ADL Traffic and Highways Engineering Ltd

Re: A38 DERBY JUNCTIONS PROJECT: DEADLINE 3 SUBMISSION

1.0 Written Summary of Oral Representation

Scale
 1:500 A4
 APPENDIX 4.0

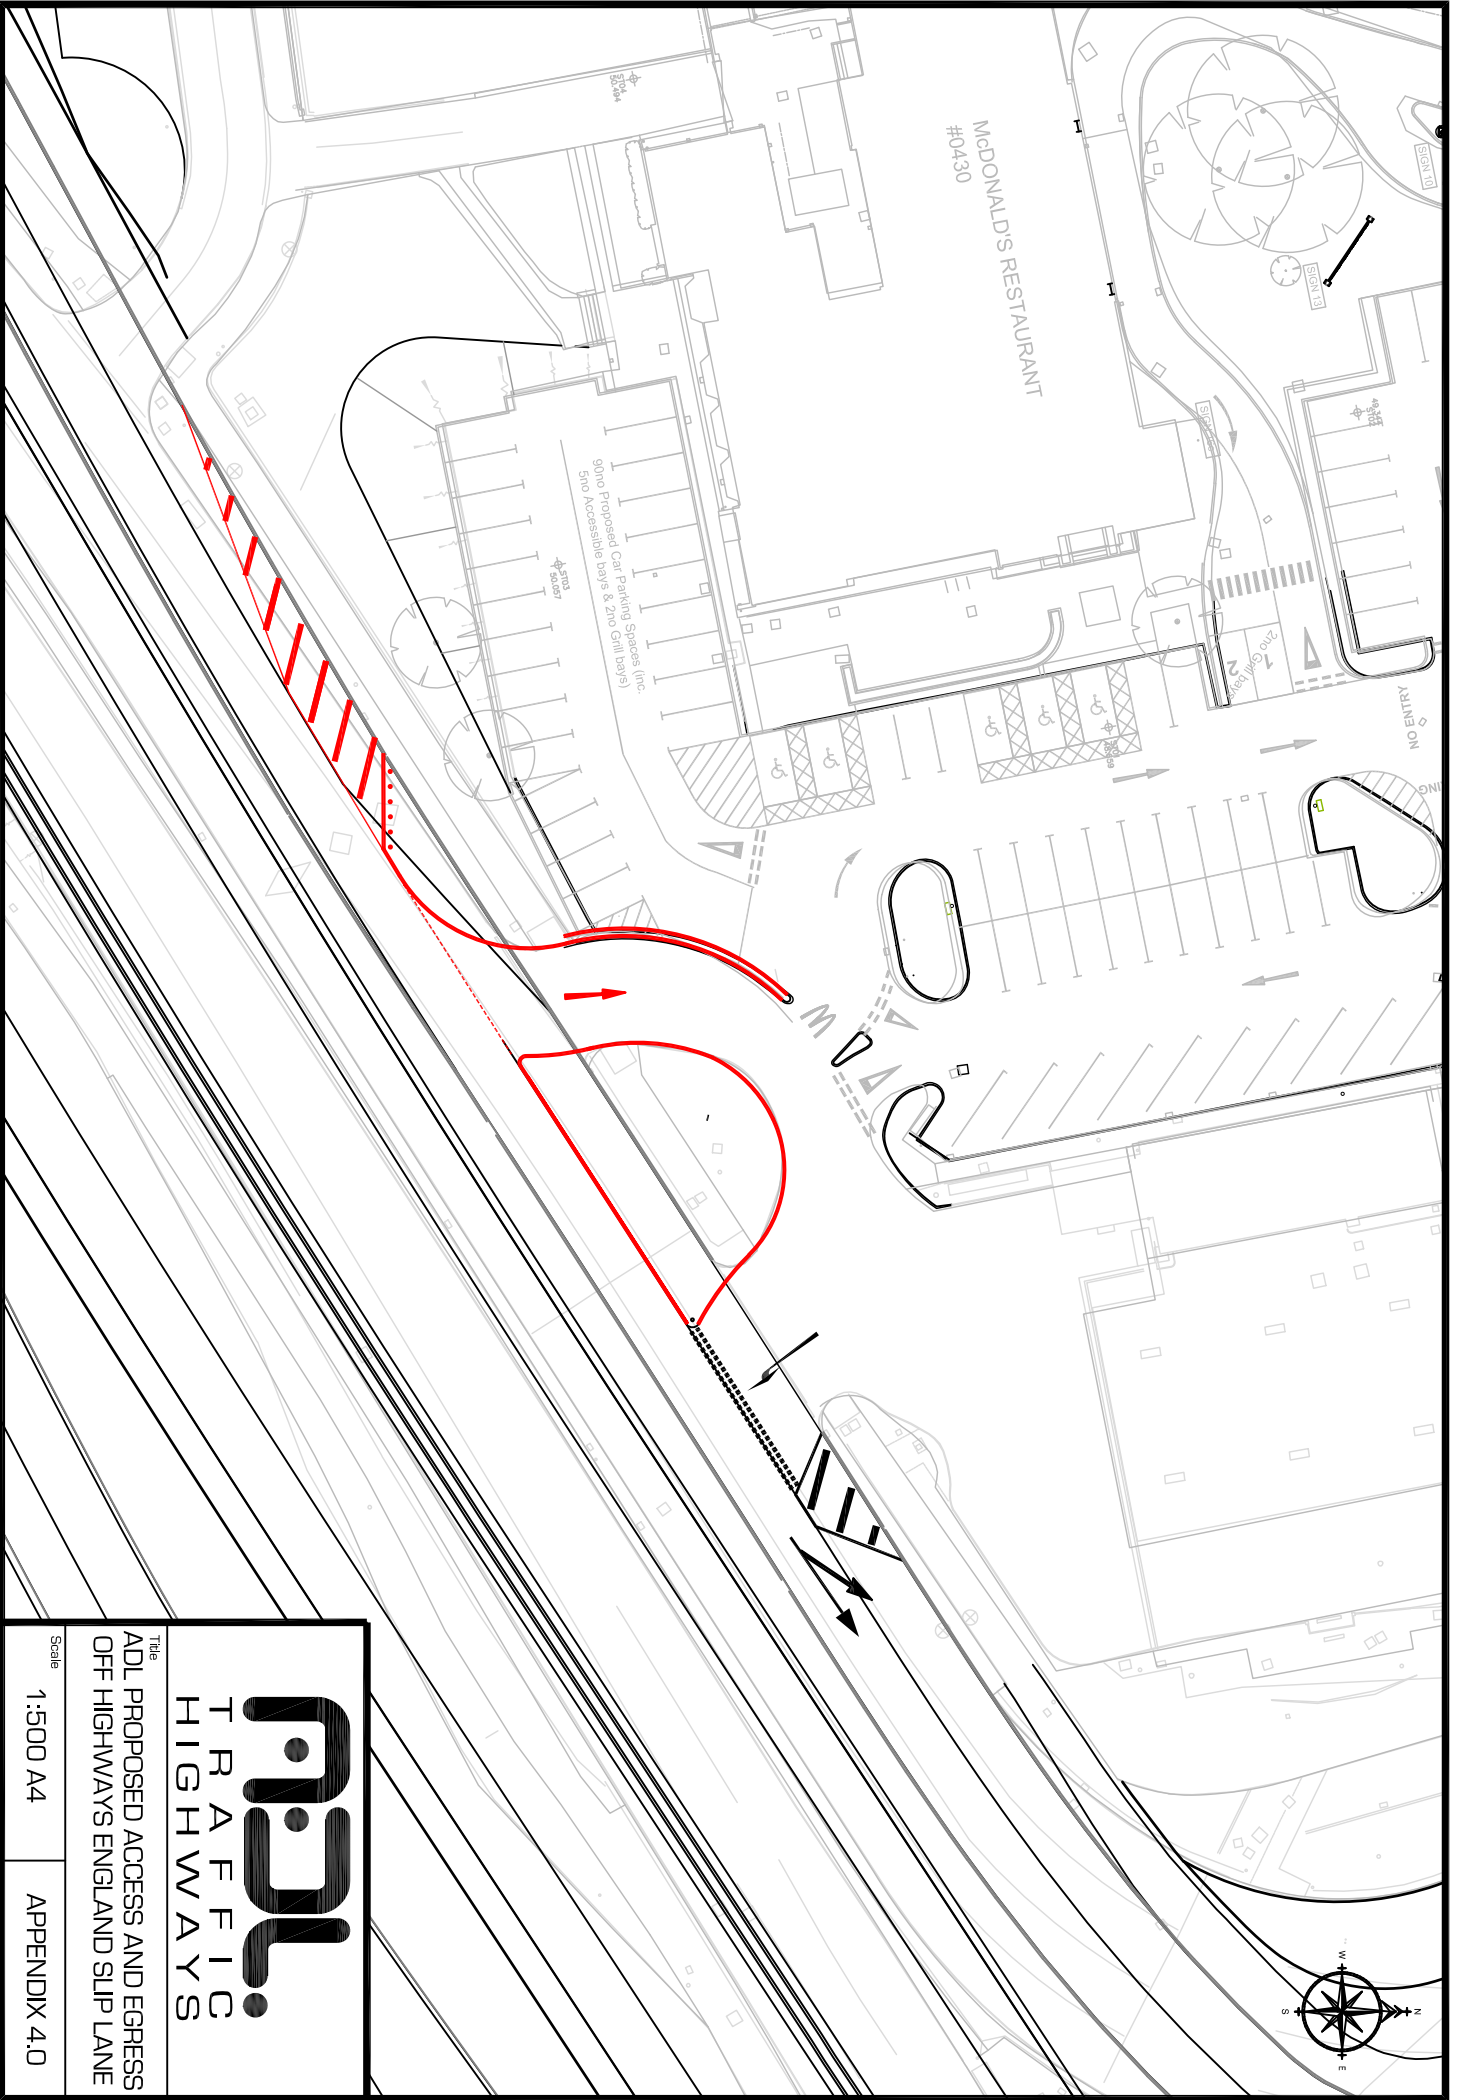
Our client has requested that we review an alternative access option and we have already supplied a sketch option in our Written Representation at Appendix 4.0 for your consideration. Whilst this is subject to Road Safety Audit and discussion with HE, our client considers that it is important that as a long established roadside operator in this location, their position is maintained to allow customers to access the restaurant conveniently.
